# Consultee Comment for planning application 21/04202/F

<b>Application Number</b>	<input type="text" value="21/04202/F"/>
<b>Location</b>	<input type="text" value="Former Buzz Bingo Bolton Road Banbury OX16 5UL"/>
<b>Proposal</b>	<input type="text" value="Redevelopment for 80 retirement living apartments including communal facilities, access, car parking and landscaping."/>
<b>Case Officer</b>	<input type="text" value="Linda Griffiths"/>
<b>Organisation</b>	<input type="text" value="Clerk to Banbury Town Council"/>
<b>Name</b>	<input type="text"/>
<b>Address</b>	<input type="text" value="Town Hall Town Hall Buildings Bridge Street Banbury OX16 5QB"/>
<b>Type of Comment</b>	<input type="text" value="Comment"/>
<b>Type</b>	<input type="text"/>
<b>Comments</b>	<input type="text" value="Banbury Town Council agree with the principle of this form of development in this location but raise concerns about the scale and siting of the blocks nearest to Trelawn House and suggest that a greater set back from the listed building be explored with reduced block sizesheights near to the listed building ."/>

Application number(s):	21/04202/F
Application site:	Former Buzz Bingo, Bolton Road, Banbur

Castle Street Elevation / North Elevation as proposed

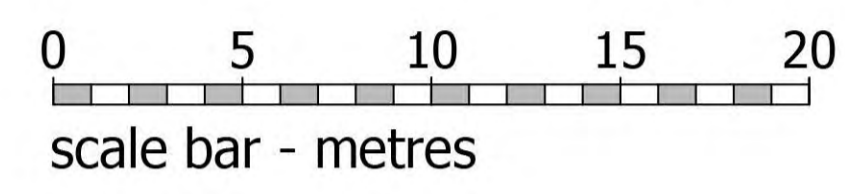
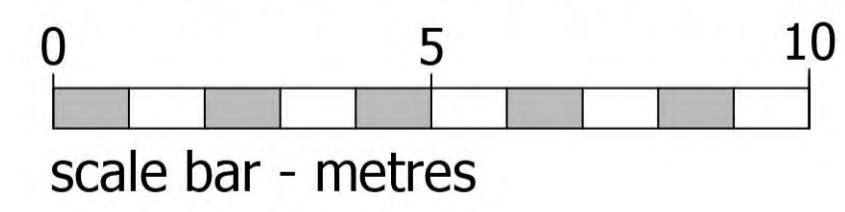
The west block on Castle Street is 3-storeys, set slightly above pavement level, this should step down to 2 storeys beside Trelawn House, and the space between the two would need further consideration. As the roof is continuous and there is a stone band separating the second and first floor it looks quite monolithic, as it lacks the usual plot width of traditional terraces normally be divided by chimneys and doors. Omitting the stone band and dividing the façade into typical 2-bay burgage plots would be more reflective of the north side of Castle Street. Chimneys can be useful for disguising ventilation and SVPs. Juliet balconies would be discouraged fronting the highway. The widths of the doors and windows look too wide and the band of masonry between ground and first floors looks too thin omitting the Juliet balconies would help. The proportions of the white block are too squat, and together with the width and colour, detracts from the scheme. The depth of the roof slope east of the white block creates a roof slope that is too big (compare with the lower 3-storey roof) and starts to make the development look contrived). It would also look better without the thin vertical strip to the eastern 4-storey block, I would rather see a 2-storey building on the corner than the 4 storeys.

North Bar Street longitudinal Elevation as proposed

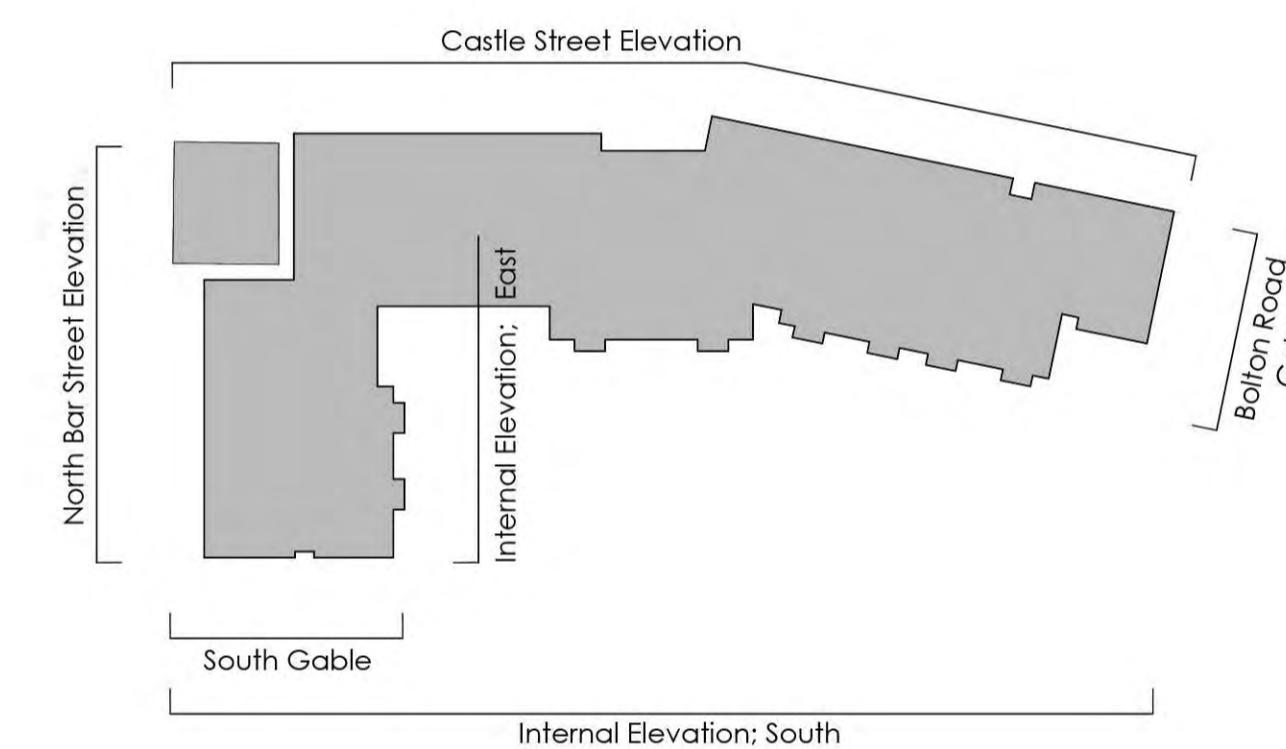
The proposed development south of Trelawn House is 3-storeys. North Bar Street rises in a southerly direction towards the south of the application site and adjoins modest 3-storey development with a higher eaves line. There would be an opportunity to have modest 3-storeys fronting the public car park with slightly higher eaves aligning with the adjacent 3-storeys, stepping down to 2-storeys towards Trelawn House. See comments elsewhere on the corner site.

The rendered painted brick looks contrived and should be removed. The non-symmetrical door with side light should be replaced with symmetrical door with no side lights. Porches should be narrower as per the red door version and their success will come down to the material and detail being authentic and appropriate for Banbury. The proportion of the windows is wider than we normally see in Banbury for sash windows, yet not tall enough for cruciform windows – both patterns can be found in Cherwell. The gap between lintels and cills would benefit from slight adjustment. Eaves should not overhang but be traditional, and boxed eaves or fascias should be avoided. Chimneys should be authentic.
